Appendix 4E

Organisation Submissions – Preferred Corridor

N5 Strategic Study – Emerging Preferred Route Corridor

1. Emerging Preferred Route Corridor

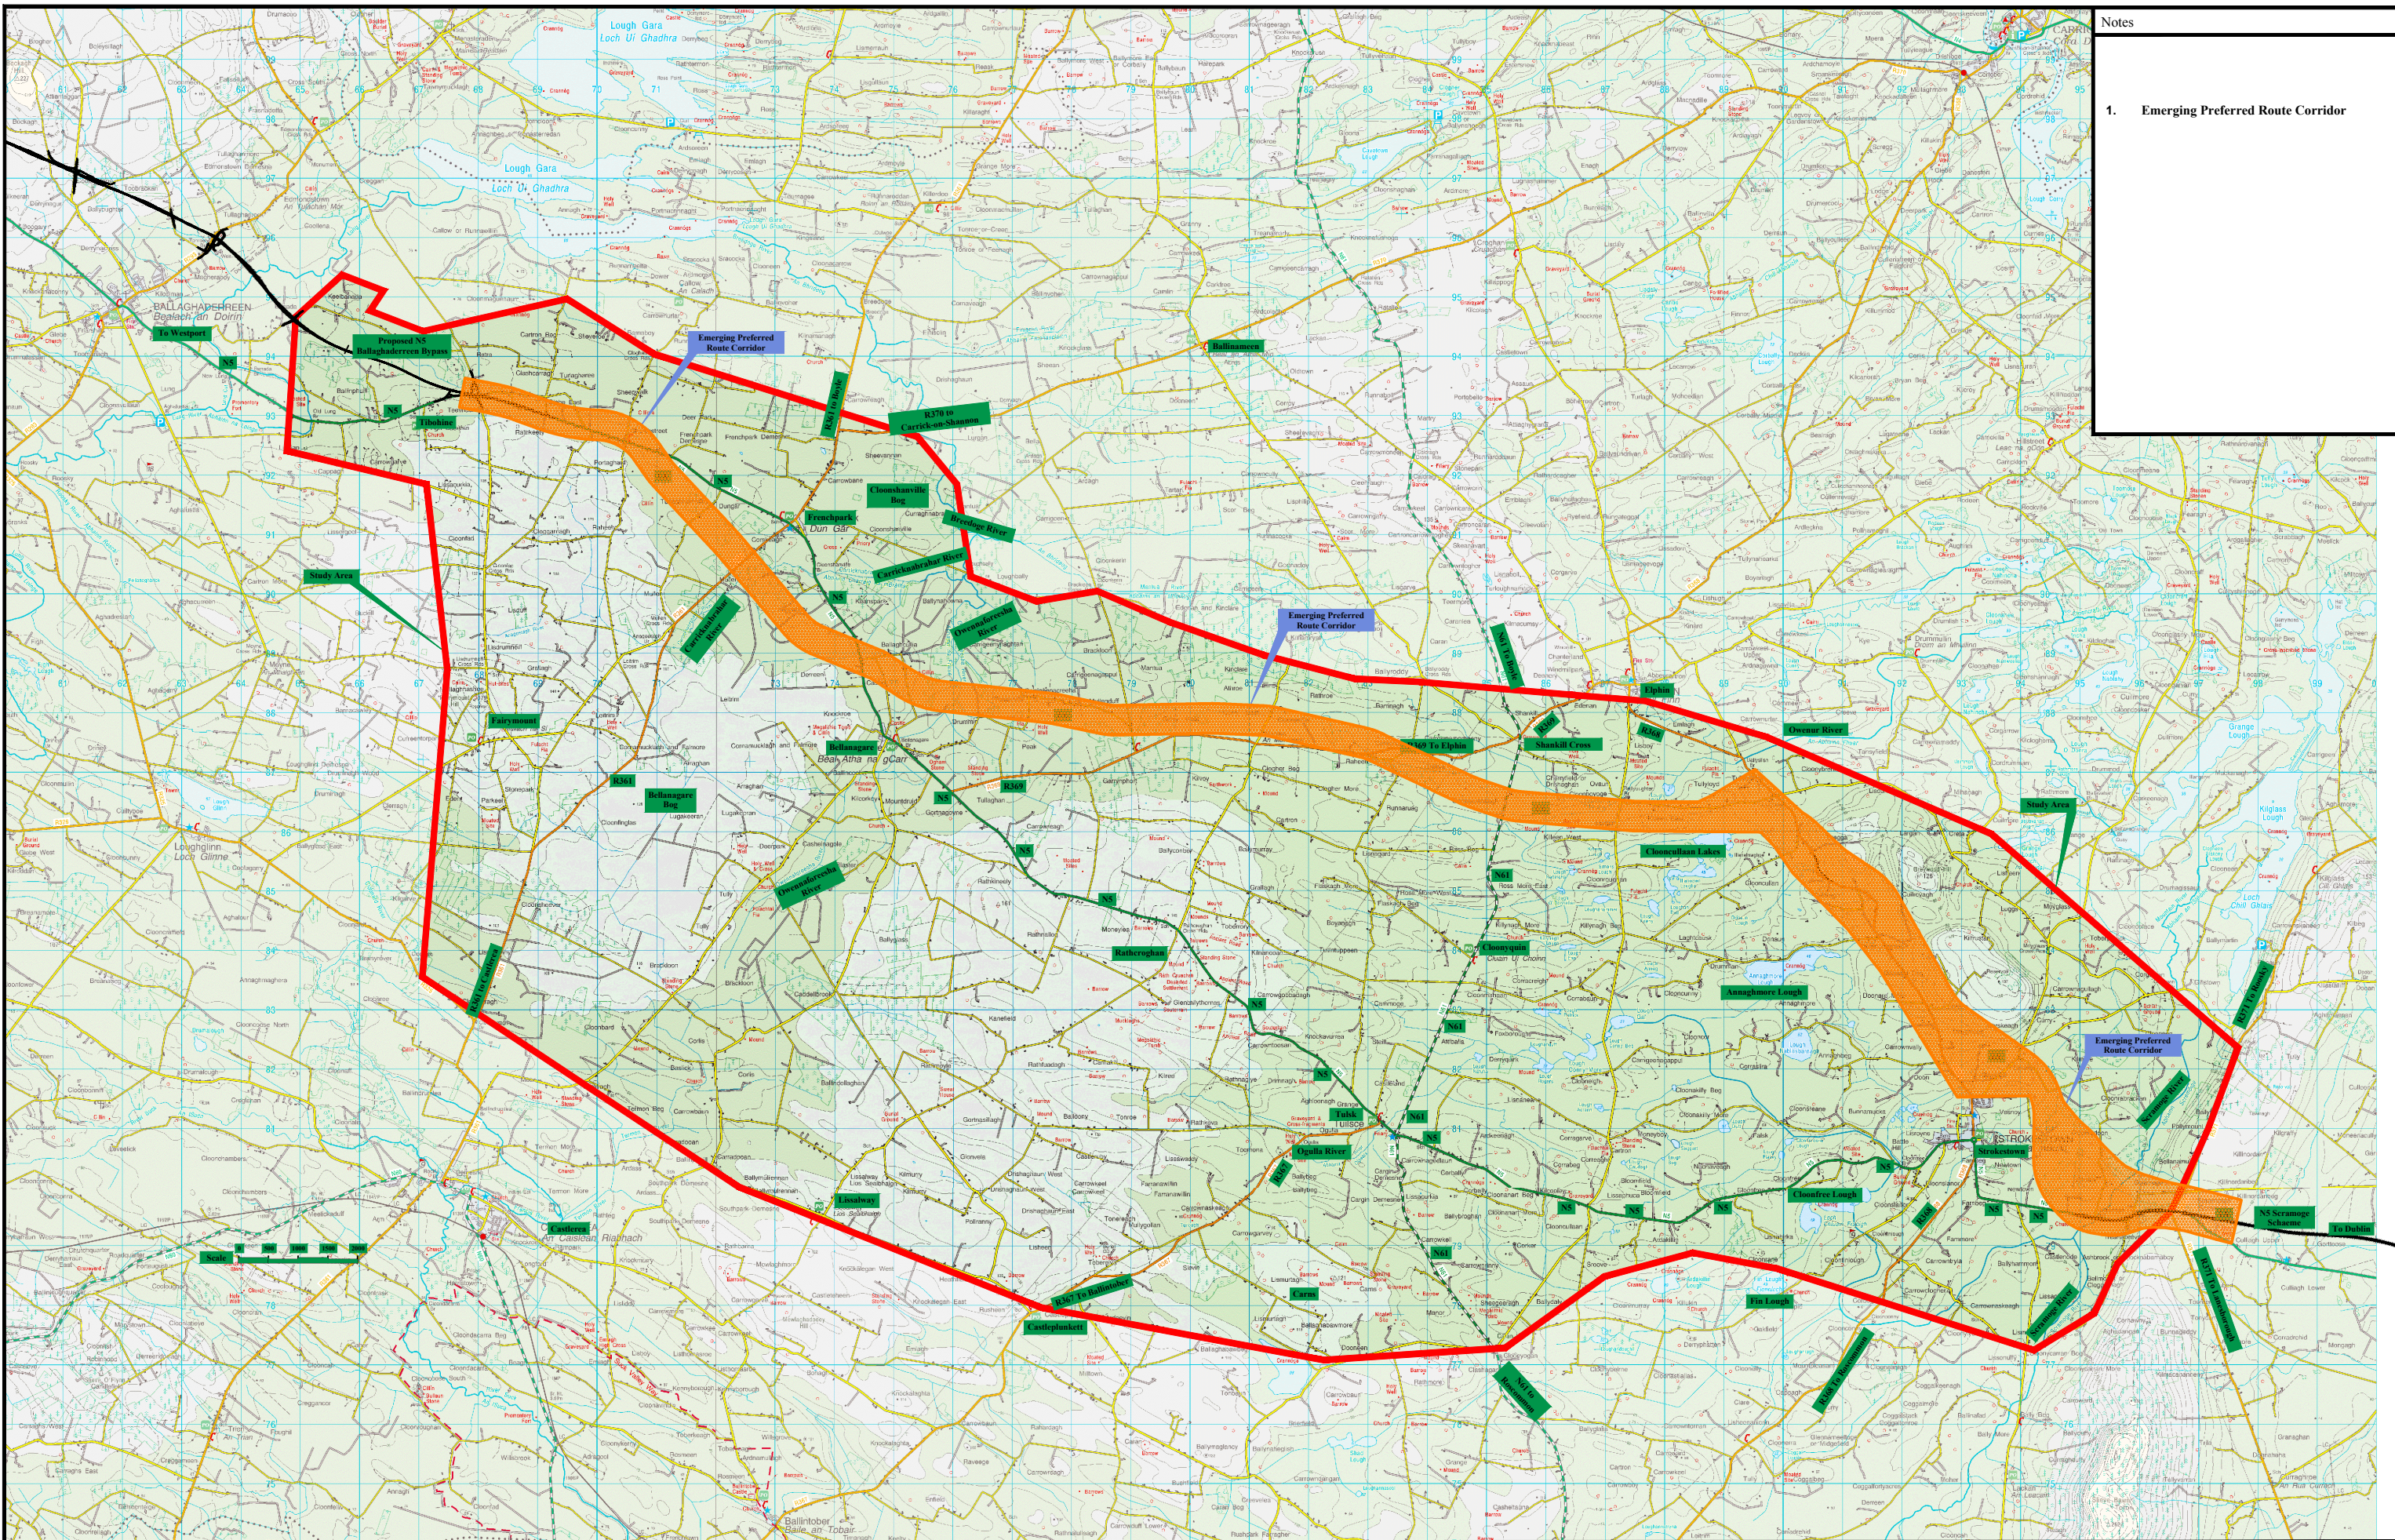
The Irish Peatland Conservation Council (IPCC) wish to make some comments on the above proposed road development. Having examined the study area map you provided, I wish to highlight the ecological importance of six peatland sites and two turlough sites that lie within or directly adjacent to the Constraints Study Area. All eight sites are currently designated for conservation. Of particular concern to the IPCC is the placing of the preferred route corridor through a large portion of Bellanagare Bog SAC 592. This bog has been designated as a Special Area of Conservation because raised bogs are listed as a priority habitat on Annex I of the E.U. Habitats Directive. The IPCC would strongly object to the placing of the N5 Strategic Corridor through Bellanagare Bog SAC 592.

The corridor crosses a number of channels associated with the Boyle Drainage Scheme, the Longford Drainage District, the Keenagh Drainage District, the Strokestown Drainage District and the Elphin Drainage District.

- That a 7m clear and level access and egress along its channels to carry out maintenance.
- That no flooding should be caused during or after construction of the project.
- Any water crossing associated with the project will require consent from the Commissioners of Public Works under Section 50 of the Arterial Drainage Act, 1945.

The route corridor includes the northernmost part of Bellanagare Bog candidate Special Area of Conservation (cSAC site code 000592) and also it runs close to Annaghmore Lough cSAC. (site code 001626). Please see copies of site synopses enclosed for your information. The qualifying interest for these SACs are as follows:

It is the Department's recommendation that the road should be positioned as far north within the preferred route corridor as possible where it skirts these cSACs. Any other important/protected habitats and species within the corridor should be protected by suitable measures.

- No vegetation removal between 1st of March and 30th of August
- No drainage which can have detrimental effect on the hydrology of the cSACs should be carried out
- An ecological assessment should be carried out on the proposed route incorporating measures to protect mammals such as Otter, Badger and Bats.

However, the proposed development traverses an archaeologically rich area and there is a strong likelihood of impact on known and previously unknown archaeological material is high. It is important that a thorough Archaeological Assessment be carried out in advance to inform design throughout the EIA process. This assessment should include a description of the known and potential archaeological remains based on results of field walking, documentary research, examination of aerial photography, examination of results of previous archaeological mitigation in the vicinity of the scheme. In addition the results of archaeological mitigation for any engineering investigations carried out, results of Underwater Archaeological Assessment, and visual impact assessment of any above ground installations or associated structures should also be included in the report. An assessment of the impact of all aspects of the development including direct and indirect impacts, off site, secondary and cumulative impacts should be considered and clearly outlined. A mitigation strategy should clearly outline the suggested measures to avoid impact on the archaeological remains. It should be noted that a code of practice has been agreed between the National Roads Authority and the Minister for the Environment, Heritage and local Government. This code suggests that mitigatory planning at the earliest opportunity minimises the impact on the archaeological heritage.

- According to your map the Ballaghaderreen Landfill Facility / Civic Amenity Site is outside the study corridor area. This landfill facility will continue to operate until 2010-2011.

- At Cregga Hill in Cuilrevagh Townland, near Hanleys quarry, a burial pit for carcasses of burnt meat exists as a result of a fire in a meat plant exists. See attached map, which also shows the location of 8 boreholes. It is just outside the band under consideration.
